**From:** Stephen Milliner [REDACTED]  
**Sent:** 01 February 2021 15:53  
**To:** Zac Denton <[Zac.Denton@arun.gov.uk](mailto:Zac.Denton@arun.gov.uk)>; Planning <[Planning@arun.gov.uk](mailto:Planning@arun.gov.uk)>  
**Subject:** EP/7/21/HH Little Dormers 23 Upper Drive BN16 1QN - "No Objection" observations and comments

I see that following the withdrawal of application EP/96/HH/20 and EP/124/20/HH that the applicant has submitted a new application and this application is much less aggressive which is encouraging. It looks like the applicant and their architect have approached the scheme with much more thought which is to be welcomed. May I offer some comments on the scheme which I would ask you to consider when determining the application.

Drawing Name
Floor Plans and Roof Plan - Proposed

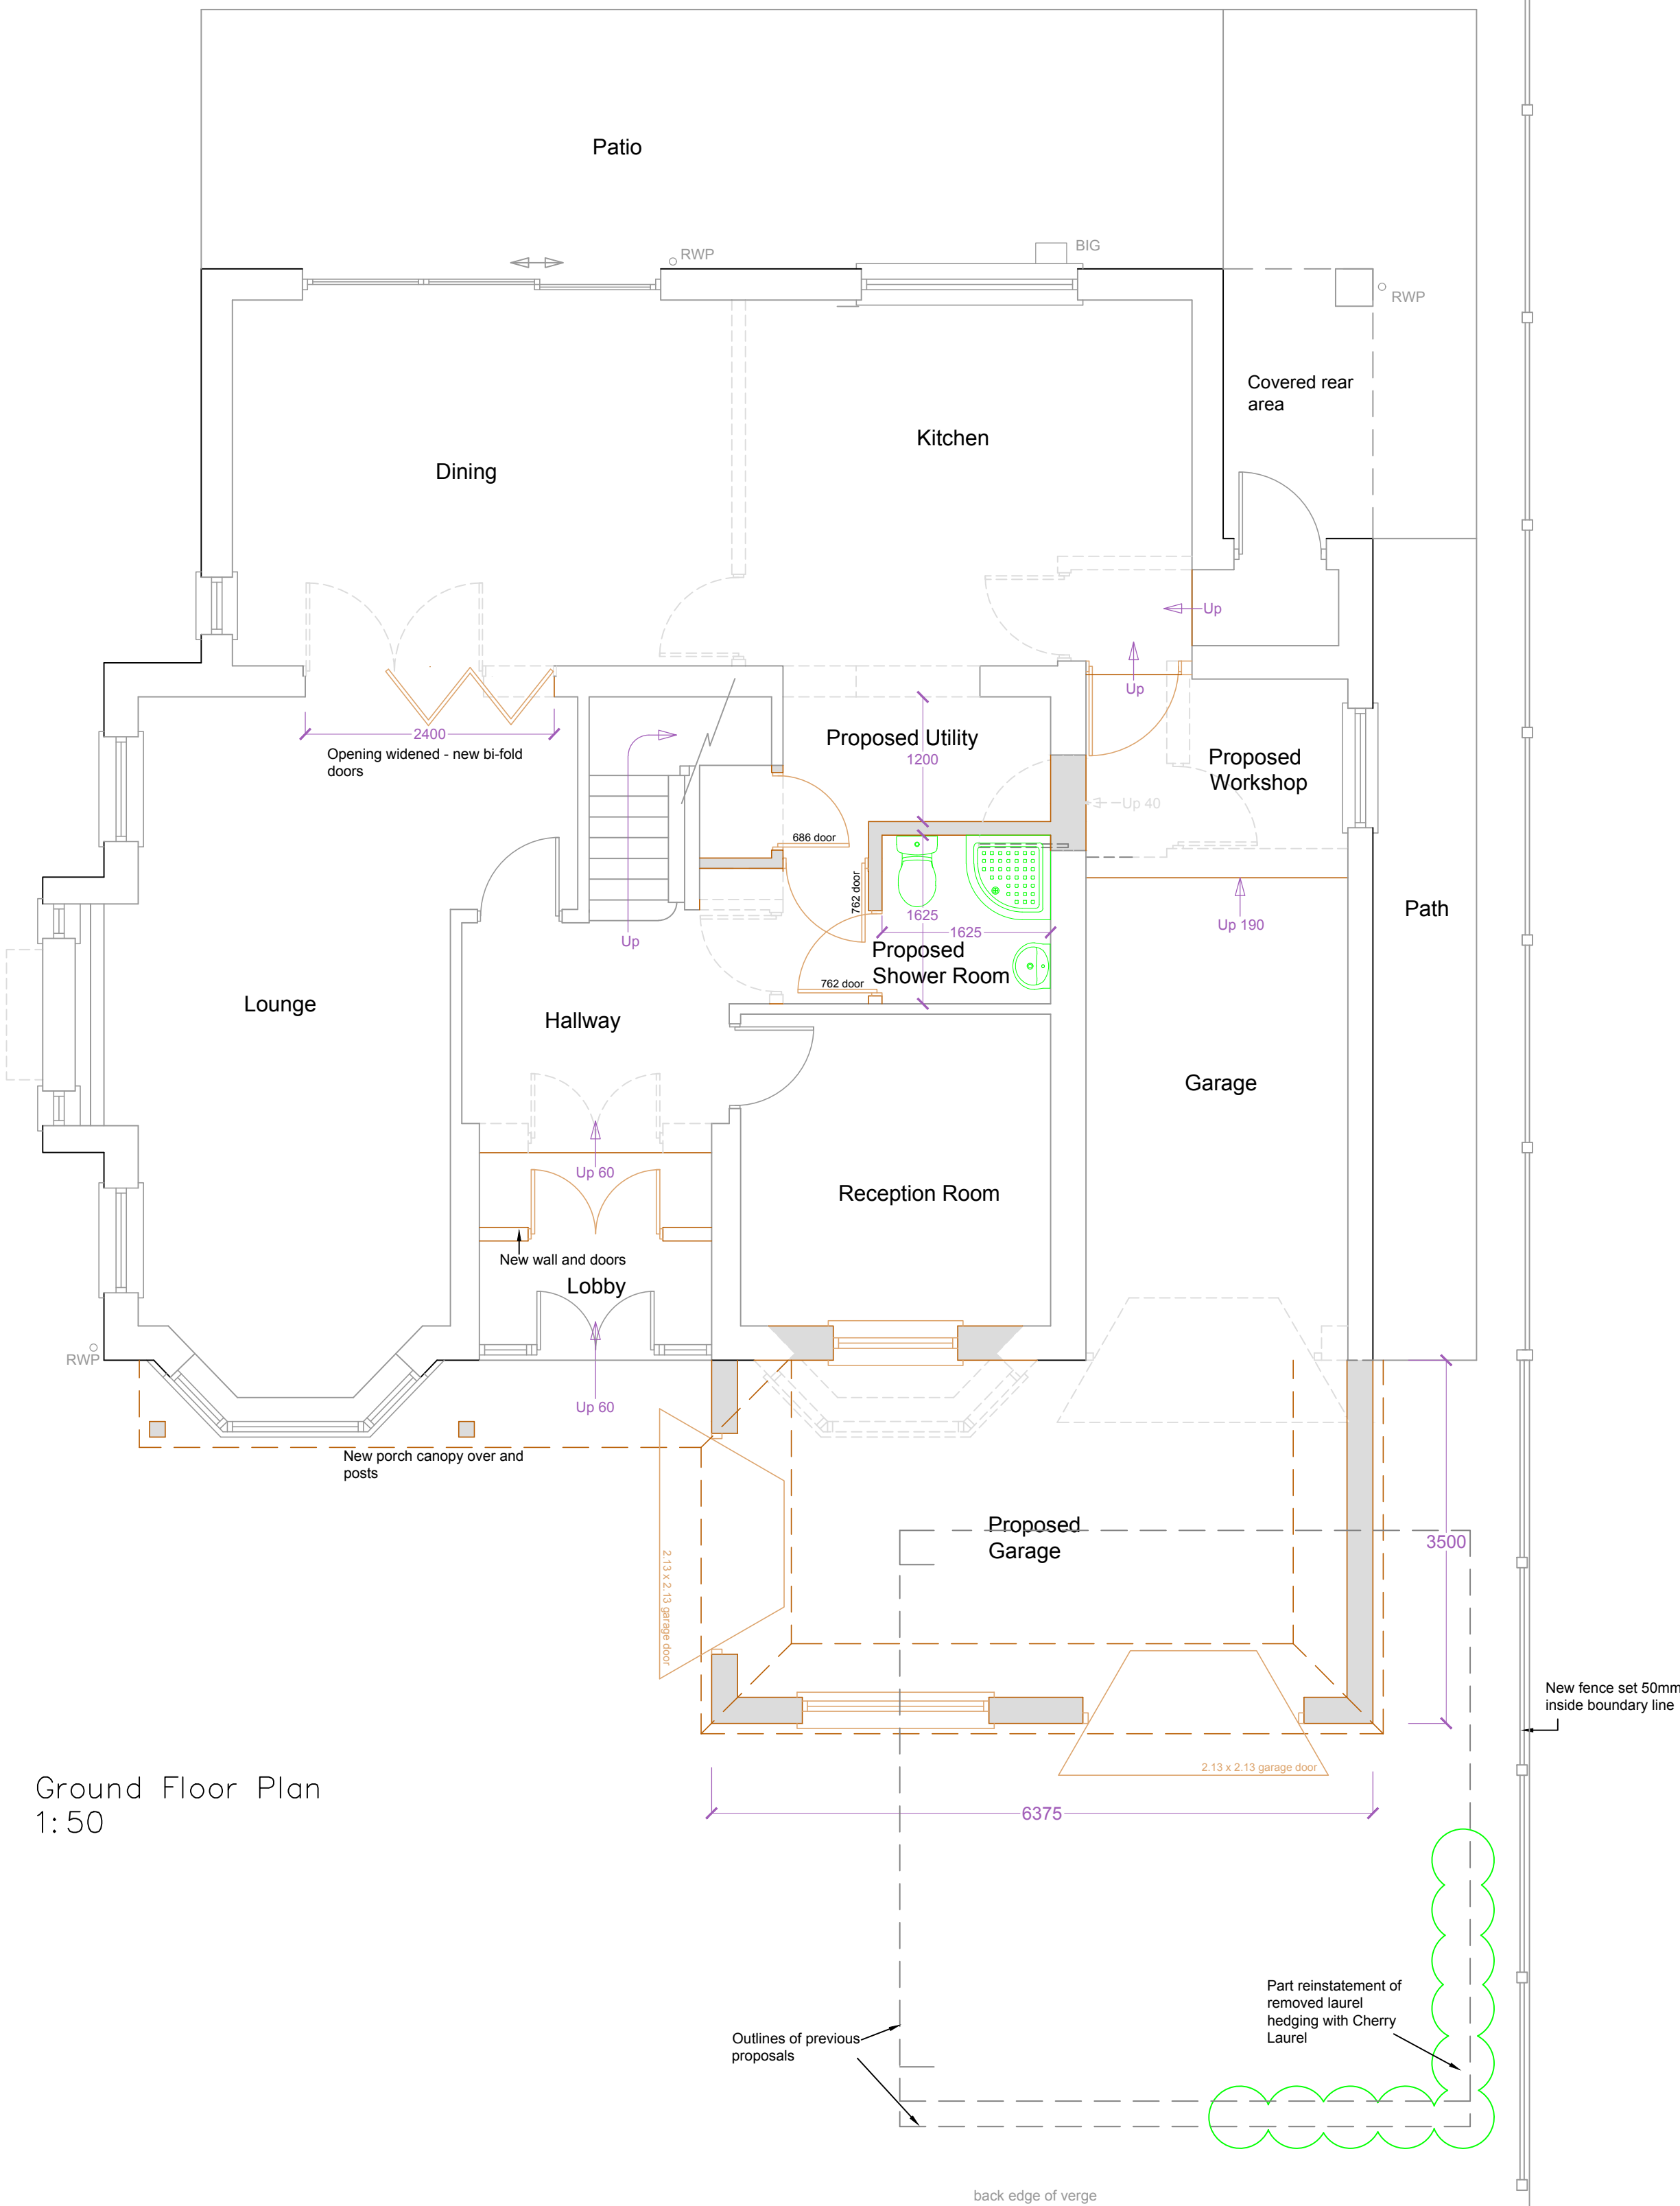
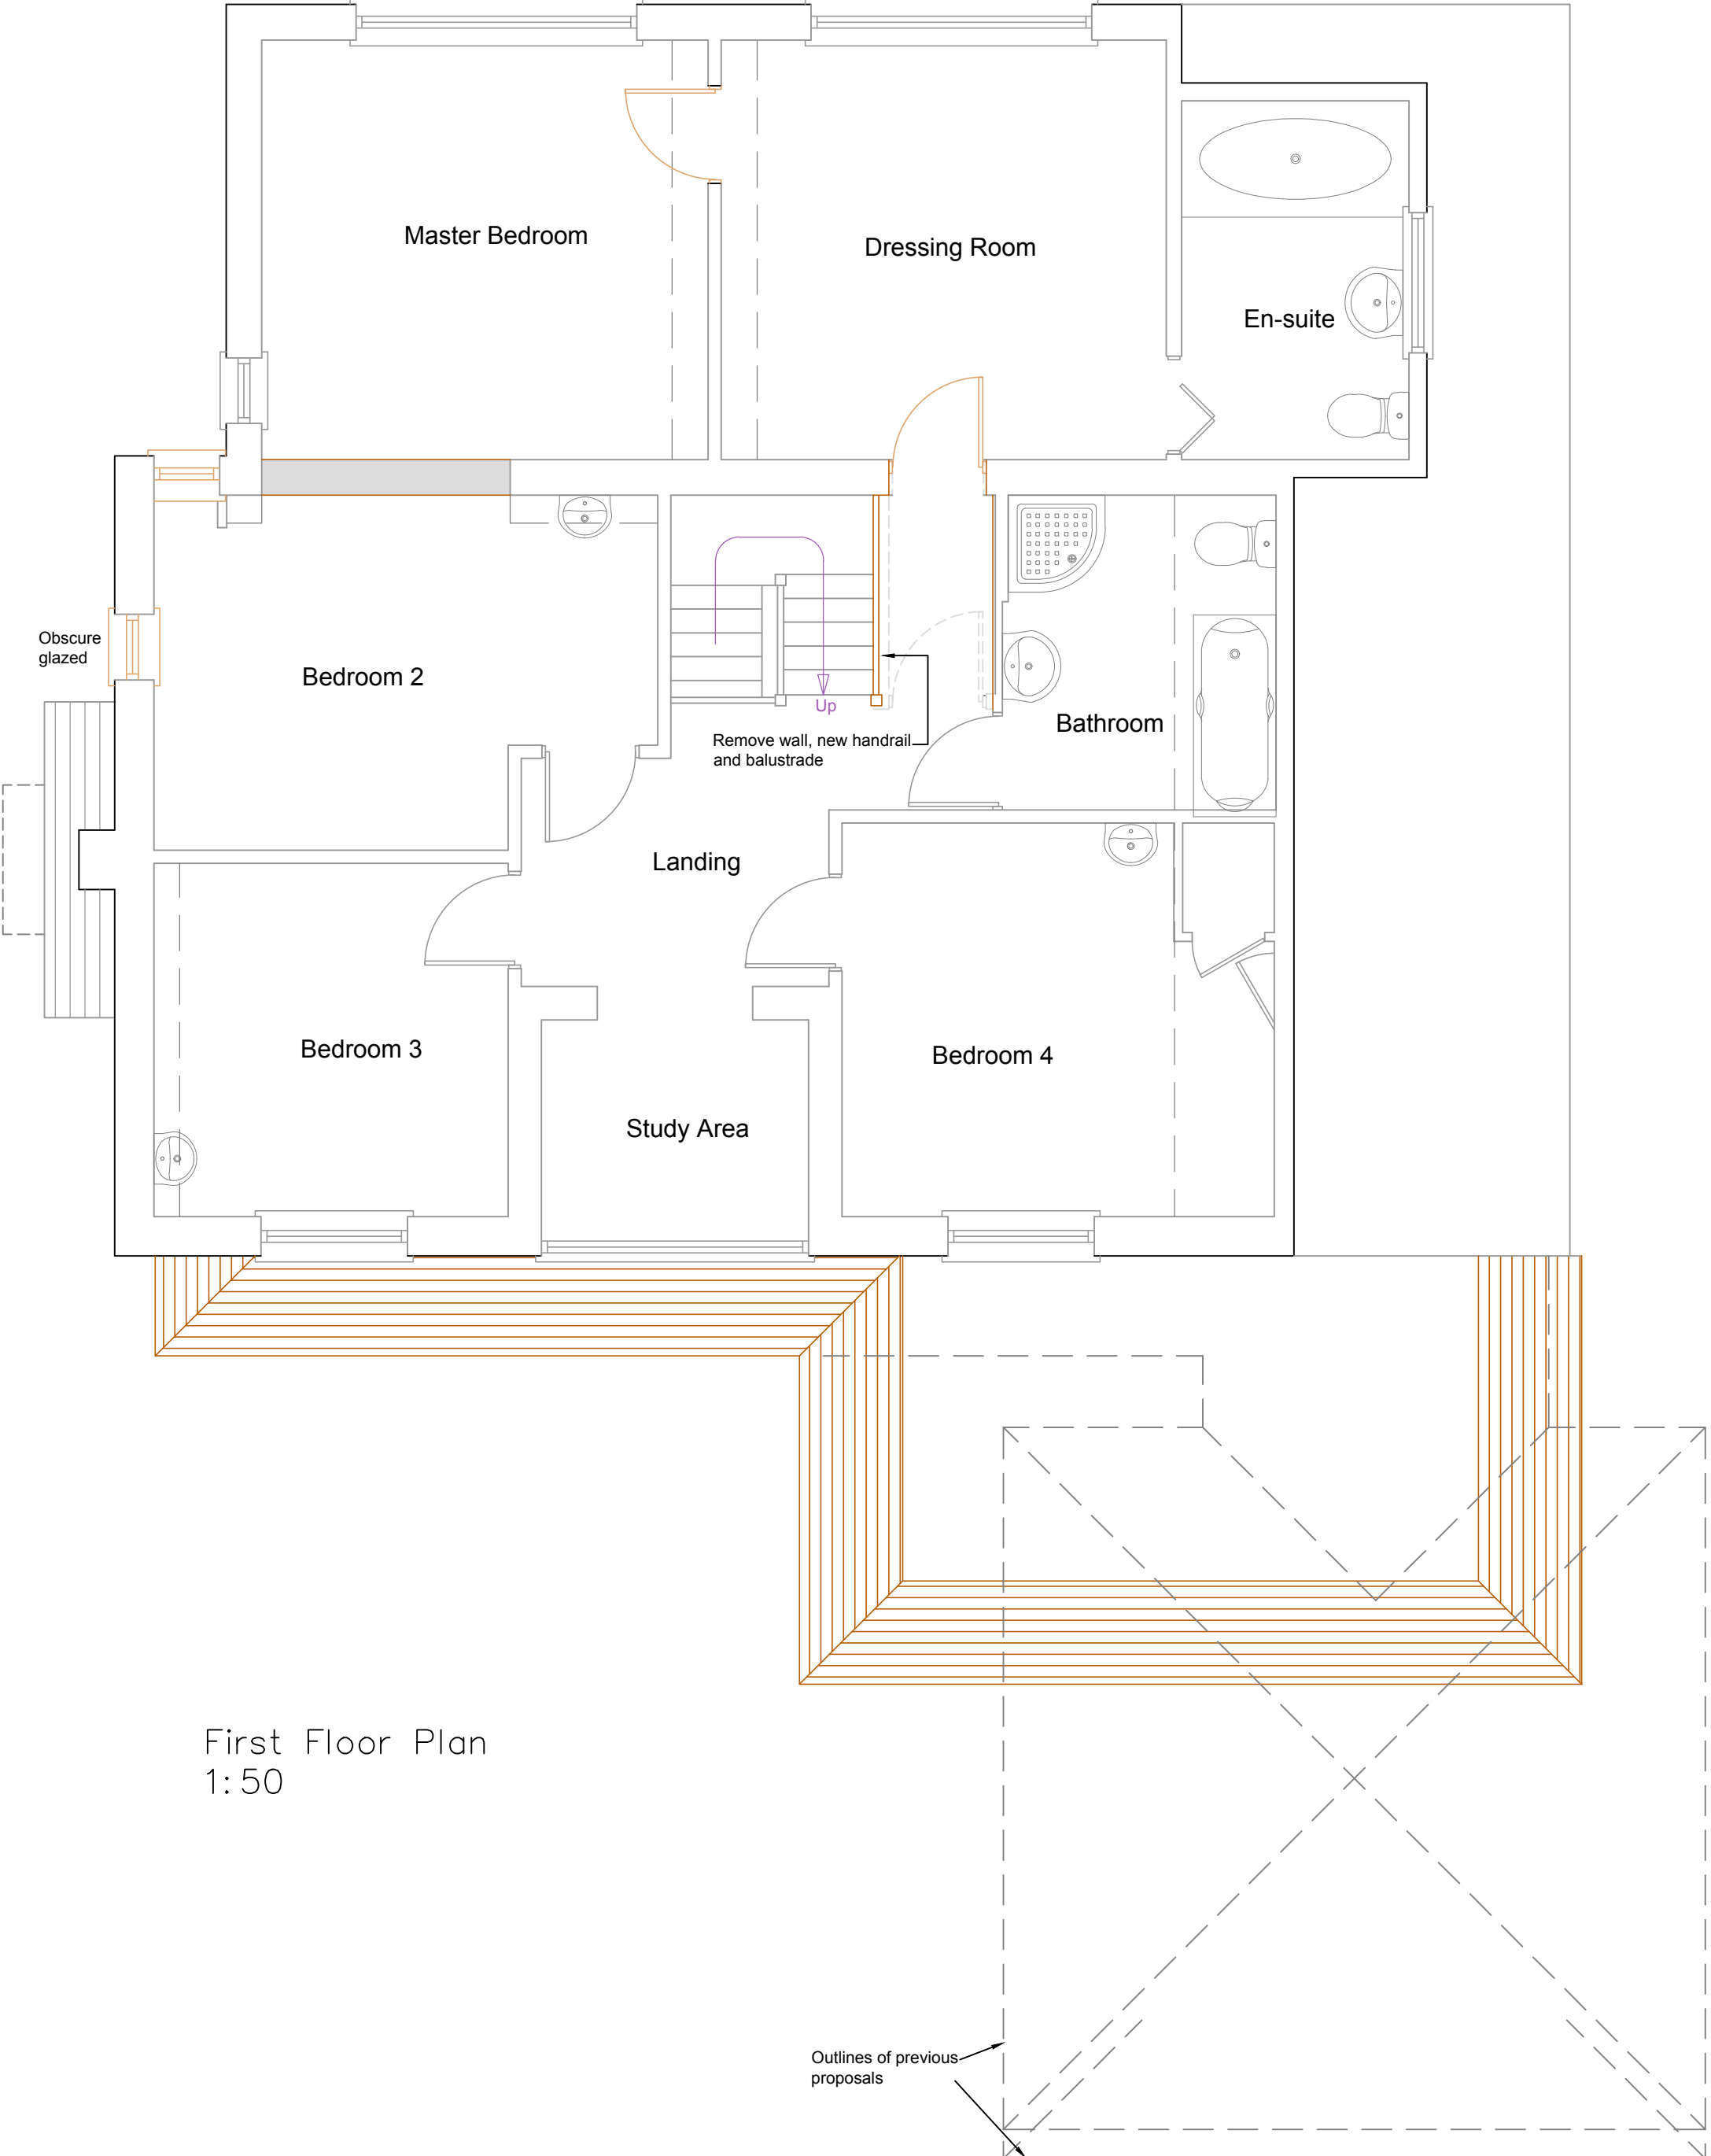
I suspect the applicant wishes to use the garage space as a garage but once built it does not prevent the current applicant or any future owner of Little Dormers from changing the new garage space to living accommodation in the future under Permitted Development Regulations and this is of significant concern as the property is already a substantial dwelling having four bedrooms so any loss of parking and an increase in living accommodation at the premises is likely to cause major issues with off street parking on the Angmering on Sea Estate where there are numerous narrow streets particularly Upper Drive and South view as examples.

The four-bedroom house currently has hard standing across the complete frontage of the site together with a garage in the NE corner of the dwelling. This proposal desires the existing garage to be kept as a garage, supplemented with a further garage in front which means that the access arrangements for vehicles will be impaired and the space in front of the proposed garage will be needed to gain access to the proposed garage. I am minded that these proposals therefore mean that some of the remaining hard standing cannot be meaningfully used as onsite parking spaces and the actual parking space provisions for the development are being reduced. Upper Drive is a very narrow road and double shuffling vehicles in this narrow road could be dangerous and annoying. In addition, as access to the existing garage will need to be through the new proposed extension this also limits the practical use of the proposed extension. However, I see the applicant is proposing landscaping at the NE corner of the site and in the round, I think there is a balance to be had and you may consider the overall parking provisions as adequate.

That those parts of the proposal shown as new garage space are used for garage/parking space only in perpetuity and any permitted development rights for the new development are extinguished. This is to avoid a change of use to further living accommodation in the future (without planning permission) increasing the likelihood of offsite parking and nuisance.

South Elevation –
(Side) 1:100

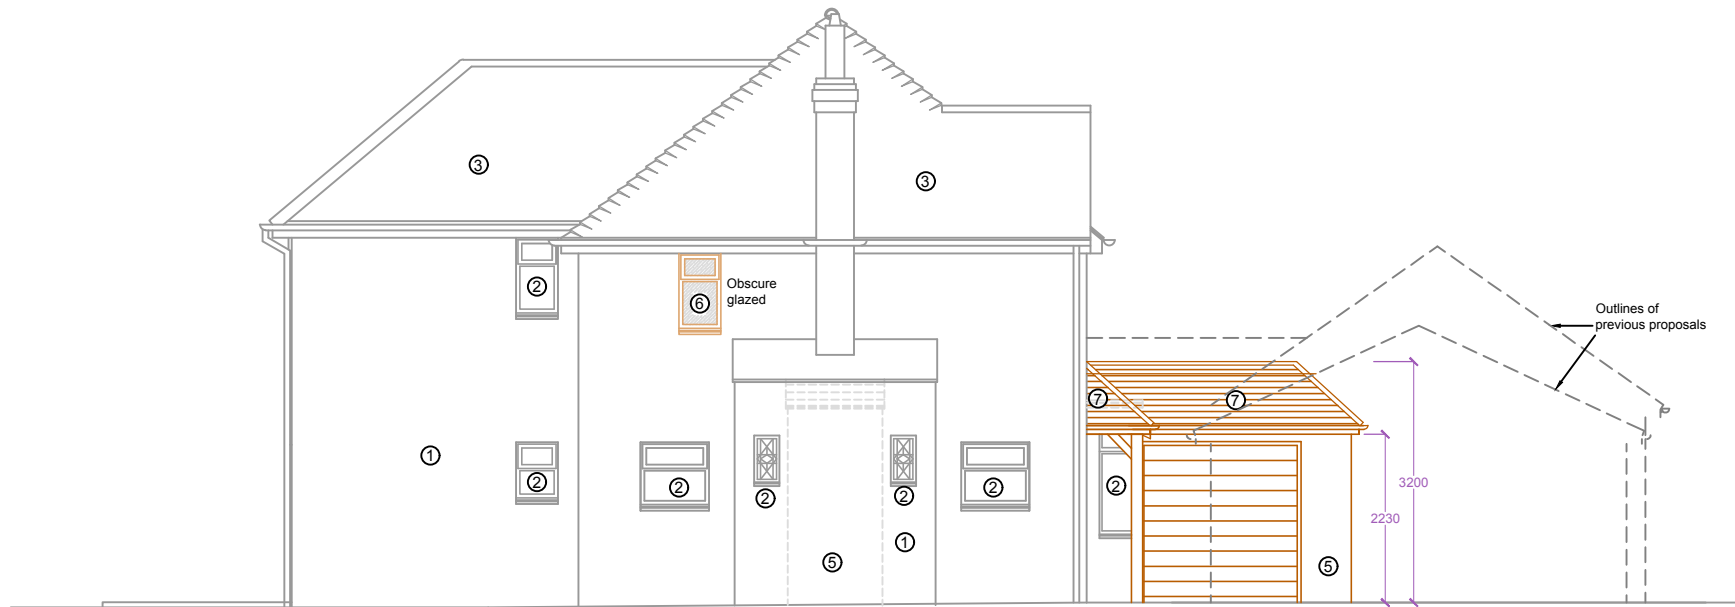
There is a new window proposed at first floor on the south elevation within bedroom 2 which may cause overlooking issues to the dwelling to the south of the development (21 Upper Drive). The applicant has shown obscure glass but also shows an opening window. The height of the opening window above the internal finish floor level is not defined and as such overlooking prevention is not confirmed on the drawing. This is in conflict with policy D DM4 although should be easily resolved by a condition.

That the overlooking issue is dealt with in a manner consistent with other planning applications and obscure glass plus non opening windows below a height of 1.8m from FFL are adopted to prevent such overlooking and be provided in perpetuity.

East Elevation –
(Front) 1:100

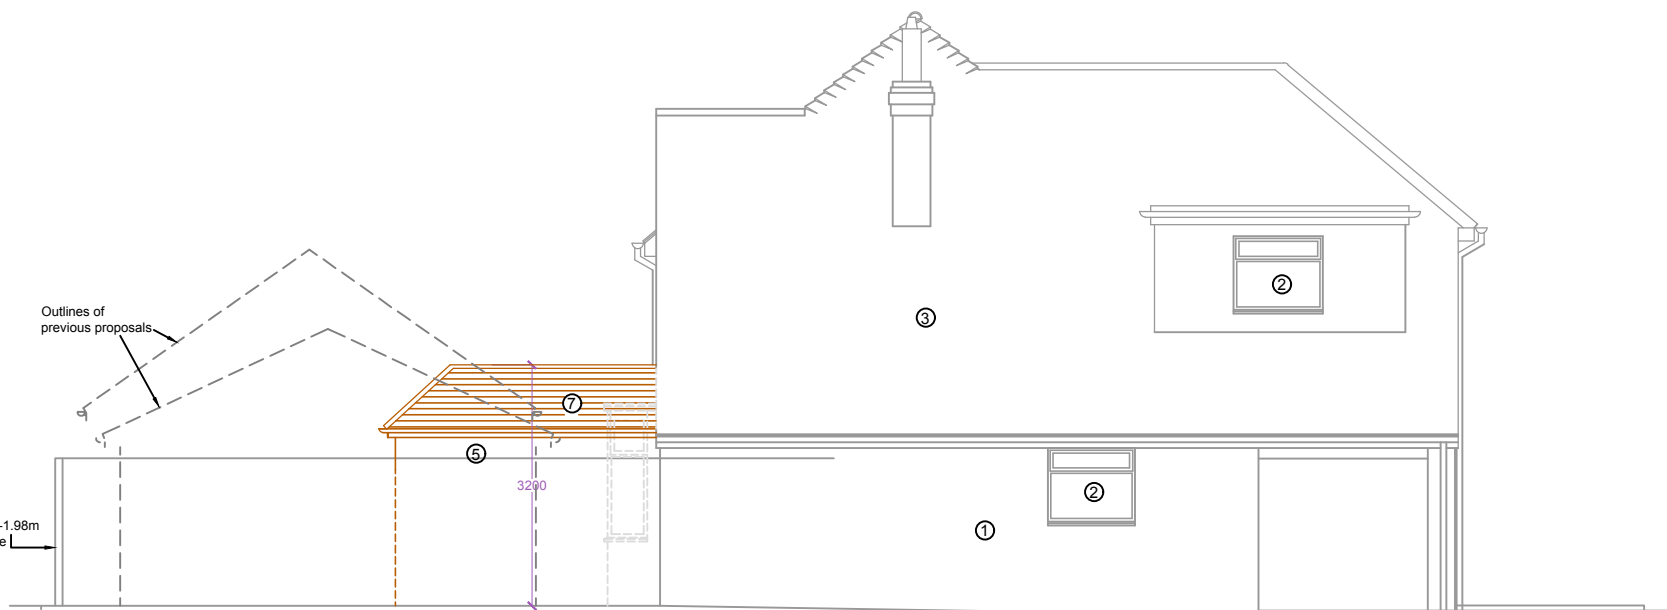
I see the new application has a window in the proposed extension on the front (east) elevation. This does balance the appearance of the front elevation avoiding a stark wall but I have some concern that this window opening from the garage could present an eyesore if you can see in to the garage from Upper Drive with the inevitable clutter that you usually get within a garage. I believe this window should have obscure glass and possibly no openings or if it has openings that they be small and at high level.

That the potential visual issue associated with a window in to the garage on the front elevation is dealt with by condition and the introduction of obscure glass with limited or no openings.
